OXFORDSHIRE COUNTY COUNCIL'S RESPONSE TO CONSULTATION ON THE FOLLOWING DEVELOPMENT PROPOSAL

Application no: 24/00539/F

Proposal: Erection of a stadium (Use Class F2) with flexible commercial and community facilities and uses including for conferences, exhibitions, education, and other events, club shop, public restaurant, bar, health and wellbeing facility/clinic, and gym (Use Class E/Sui Generis), hotel (Use Class C1), external concourse/fan-zone, car and cycle parking, access and highway works, utilities, public realm, landscaping and all associated and ancillary works and structures

Oxfordshire County Council acting as the Local Highway Authority have the following comments to make regarding the 'North Oxford VISSIM Model Scoping' note. These comments should be considered alongside National Highways' comments who are responsible for the Strategic Road Network (including A34) and may have additional requirements for modelling.

Figure 3.1: North Oxford VISSIM Model Extent

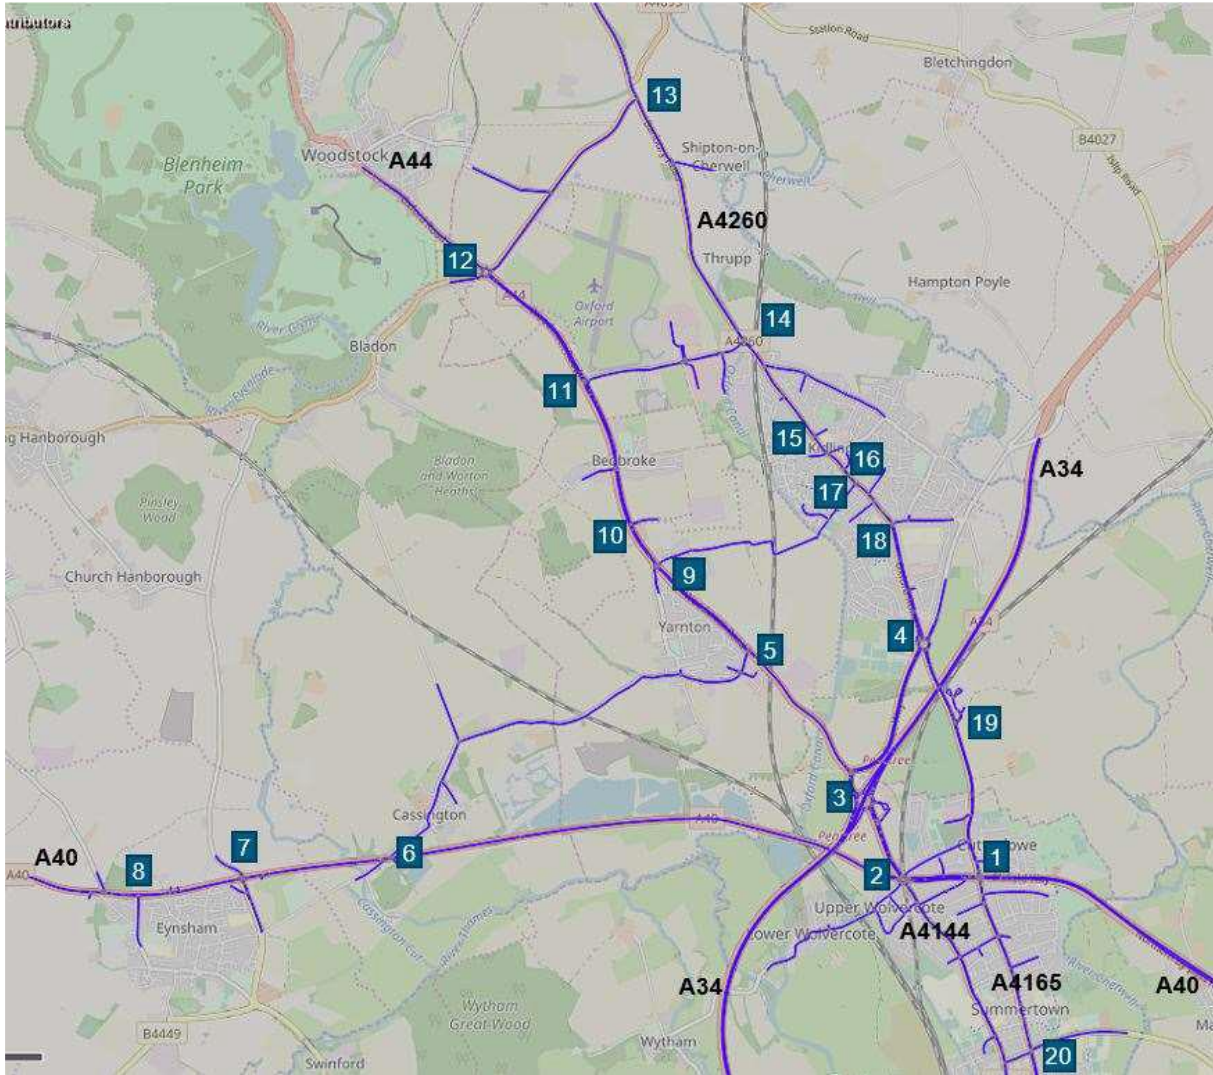
- Table 3.1 does not reference that the Existing 2018 Base Model is a weekday model. The applicant will need to set out the process for development of a weekend model.

Figure 4.1: OUFC VISSIM Model Extents

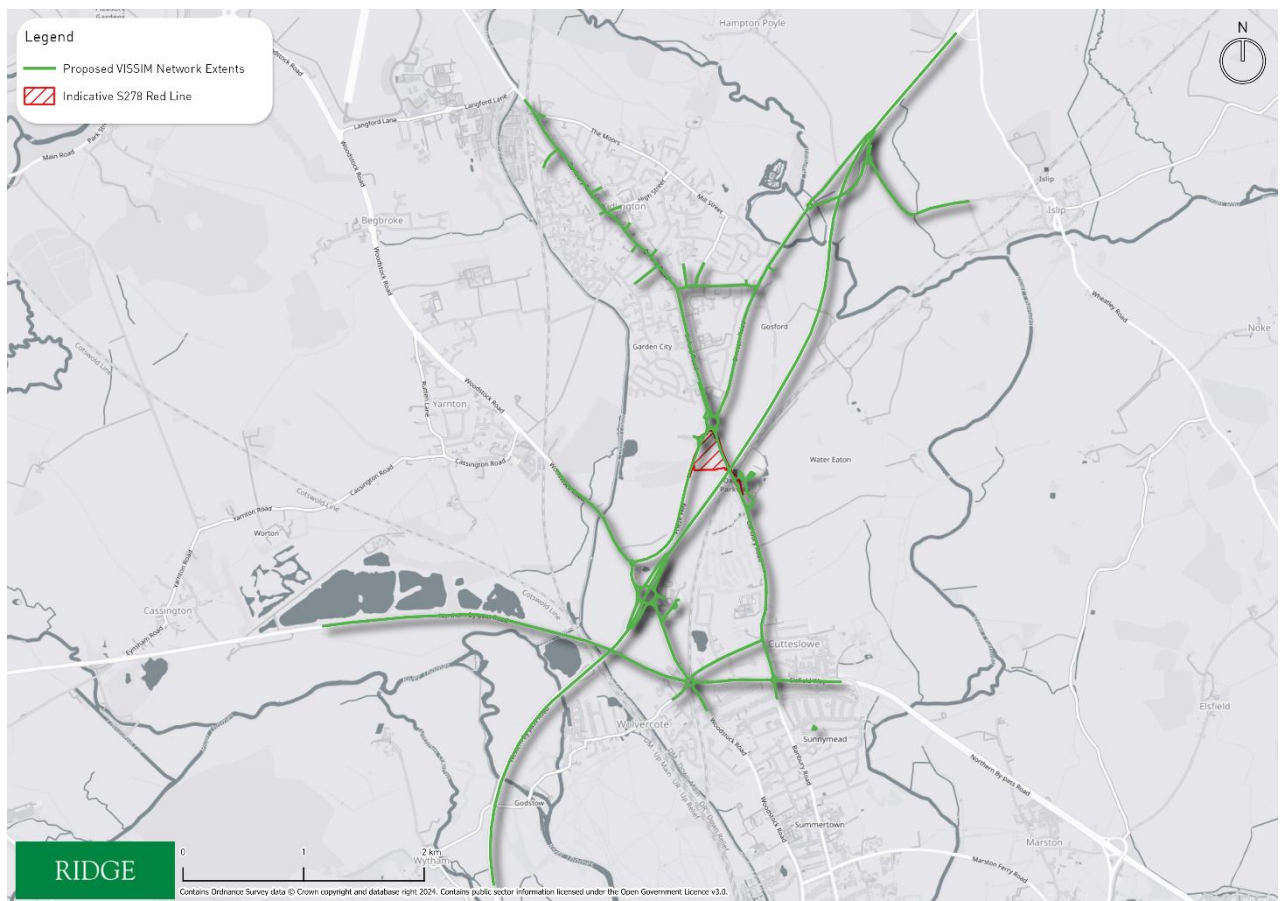
The extent of the model is required to increase beyond the network indicated in Figure 4.1 to include the following key locations:

- West along the A40 to include Cassington lights.
- North along the A44 to Langford Lane, with Langford Lane included as a connector between A44 and A4260 to allow for traffic reassignment to A44.
- East on the A40 northern bypass to include Marston Interchange.
- South on Woodstock and Banbury Roads down to the junction with Marston Ferry Road.

If queues extend beyond the network, vehicles not loading into the network will need to be reviewed.

Whilst vehicles can be assigned within this 'cordoned' area, it is recommended that the original network extents are retained so that the routes of buses can remain (and thus journey times be adequately simulated). This approach should also make coding easier given that there will be no need to remove parts of the network nor change bus routes.
